# Rezoning Transportation Analysis

Petition Number: 2023-094

**From: Jake Carpenter, PE**  
Jacob.Carpenter@charlottenc.gov  
980-221-5675

RZ-1.0

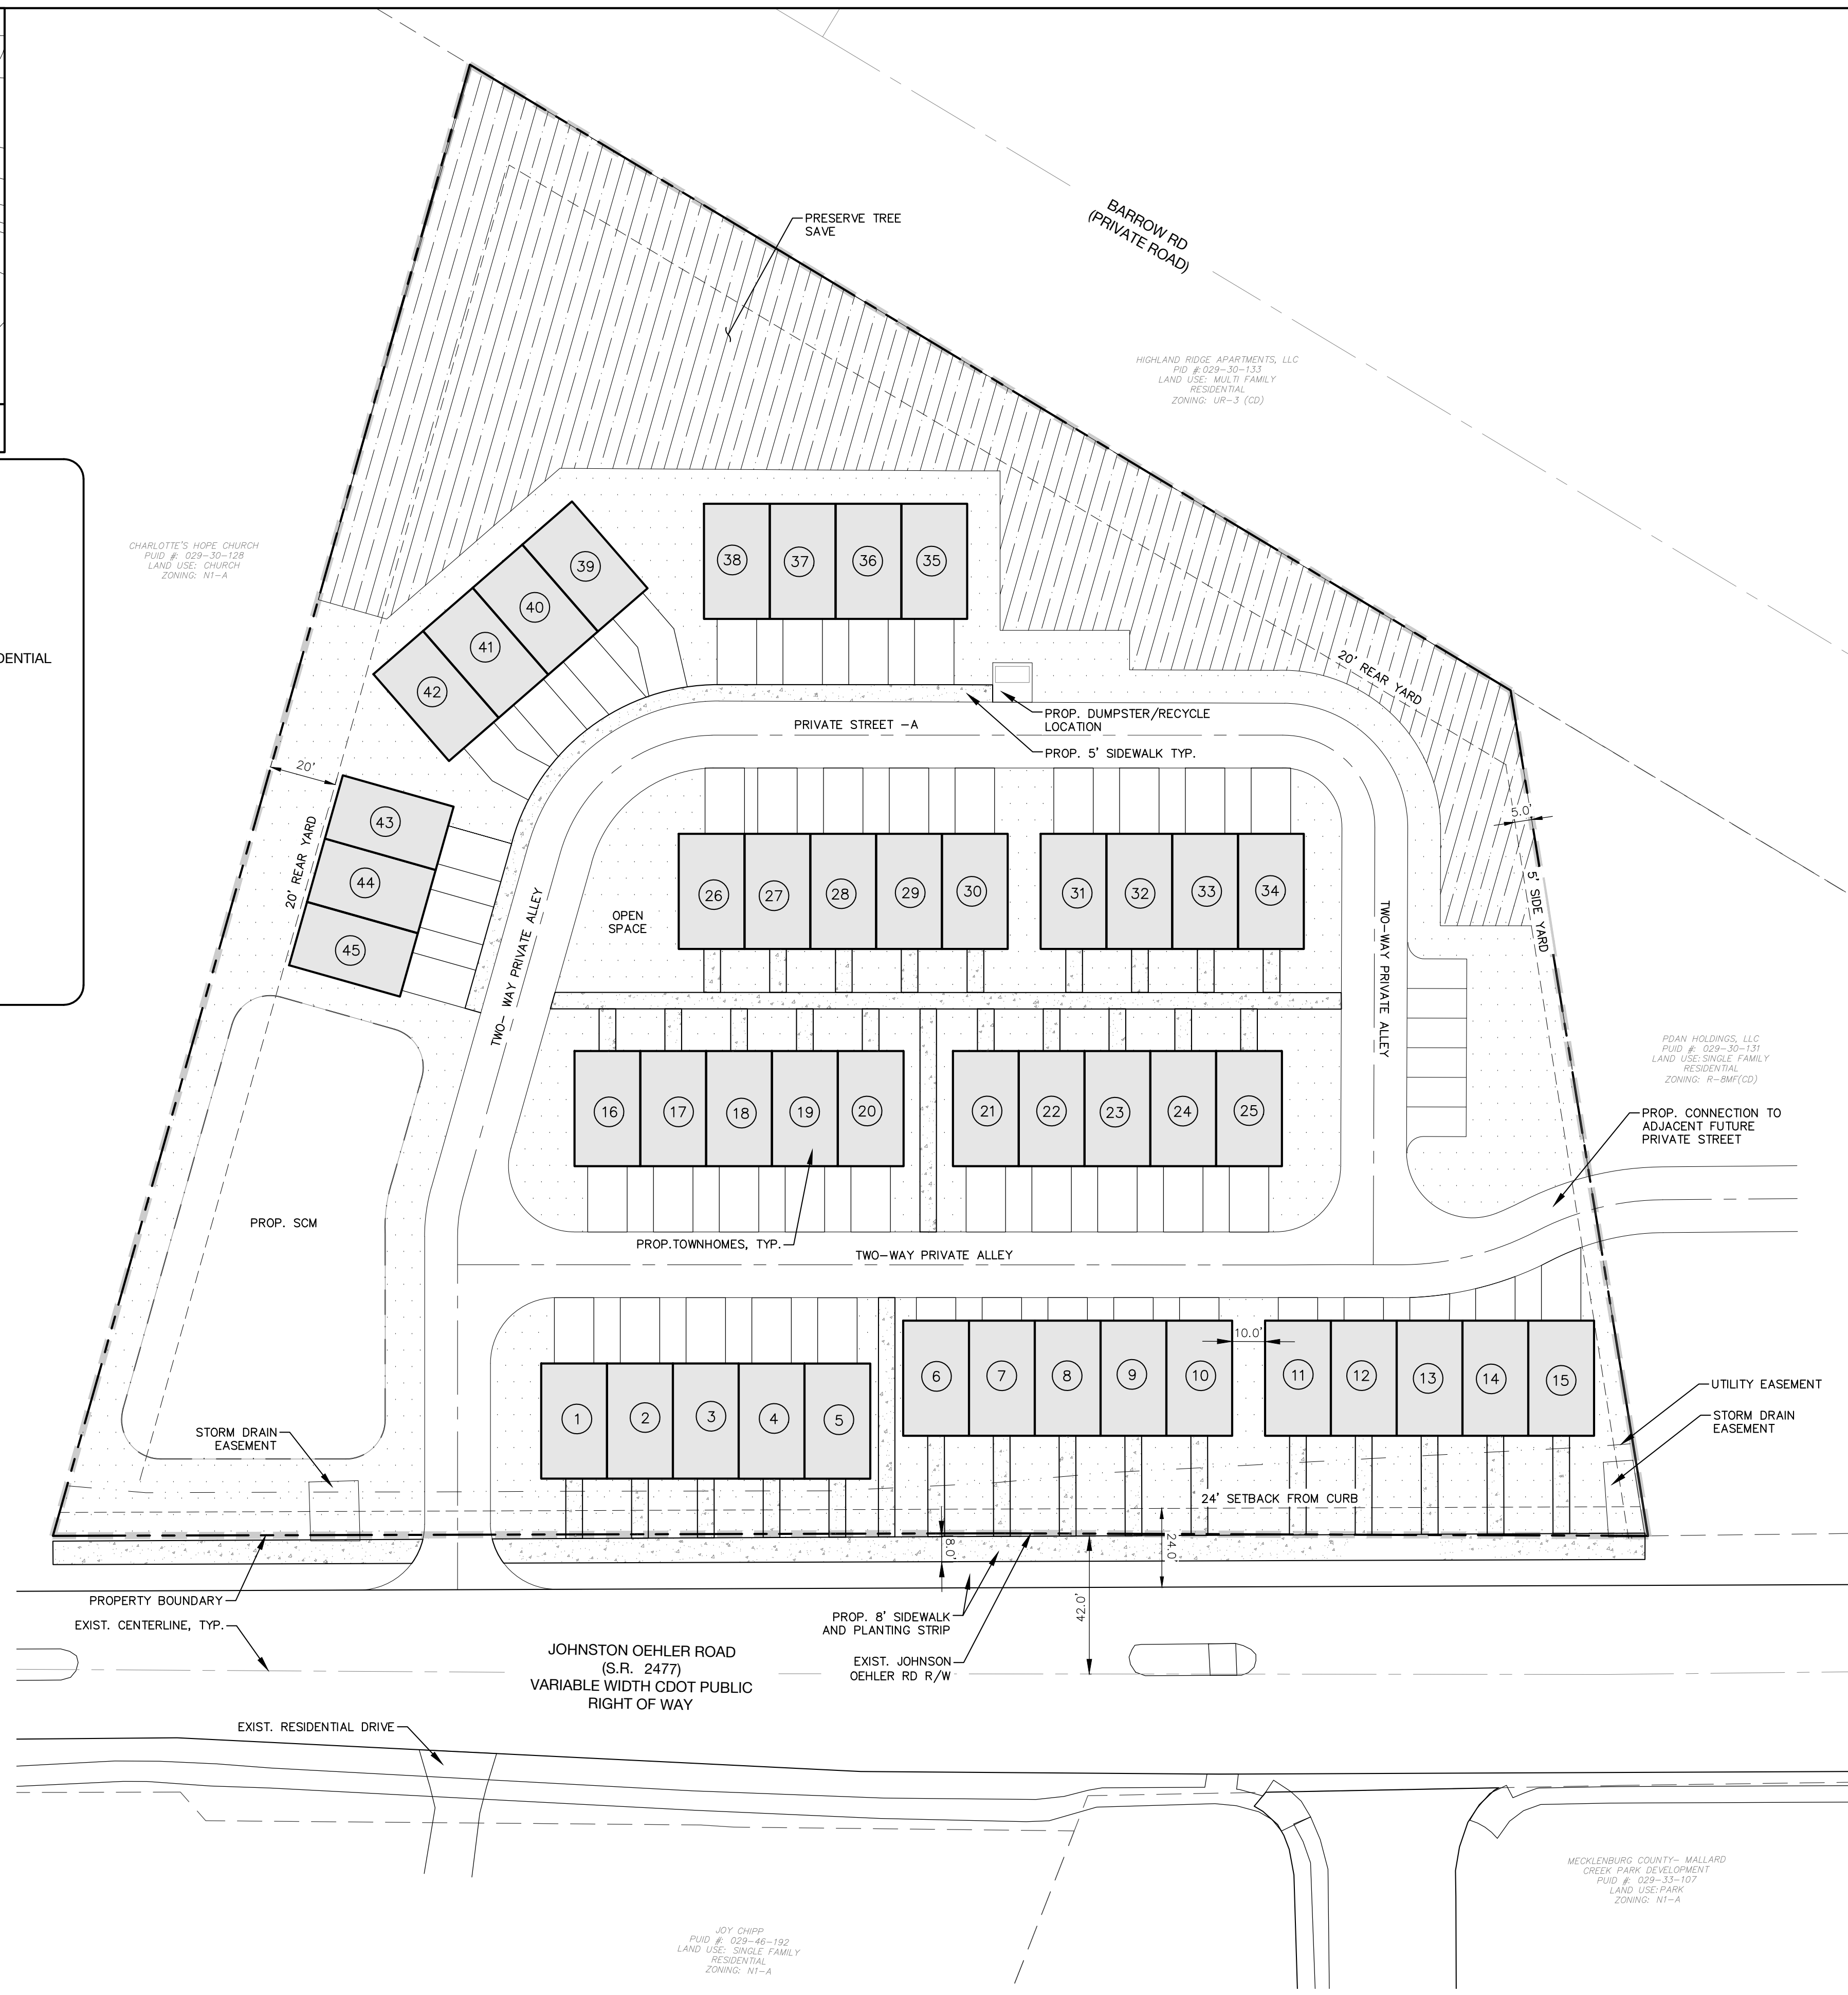
5. **Outstanding Comment from 9-28-23:** Revise site plan and conditional note(s) to commit to lining up driveway with driveway on the Southern side of the roadway.

**Clarifying Comment from 10-26-23:** Site access is to line up with the residential driveway on the southern side of the roadway. See image below.

6. **Outstanding CDOT REQUEST from 09-28-23:** Revise site plan and conditional note(s) to commit to installing a signalized pedestrian crossing at the existing pedestrian crossing location that would allow for connection to Mallard Creek High School.
7. ~~Add a conditional note specifying "the Petitioner shall dedicate and convey in fee simple all rights-of-way to the City before the site's first building certificate of occupancy is issued. CDOT requests rights-of-way set at 2' behind back of sidewalk where feasible."~~
8. ~~Add a conditional note specifying "All transportation improvements will be approved and constructed before the site's first building certificate of occupancy is issued."~~

9. **New Comment 10-26-23:** Remove conditional note referencing reverse angle parking

5. THE PETITIONER AGREES TO COORDINATE WITH CDOT ON ALL APPROPRIATE SIGNAGE RELATED TO THE PROPOSED REVERSE ANGLE PARKING DURING THE PERMITTING PROCESS.
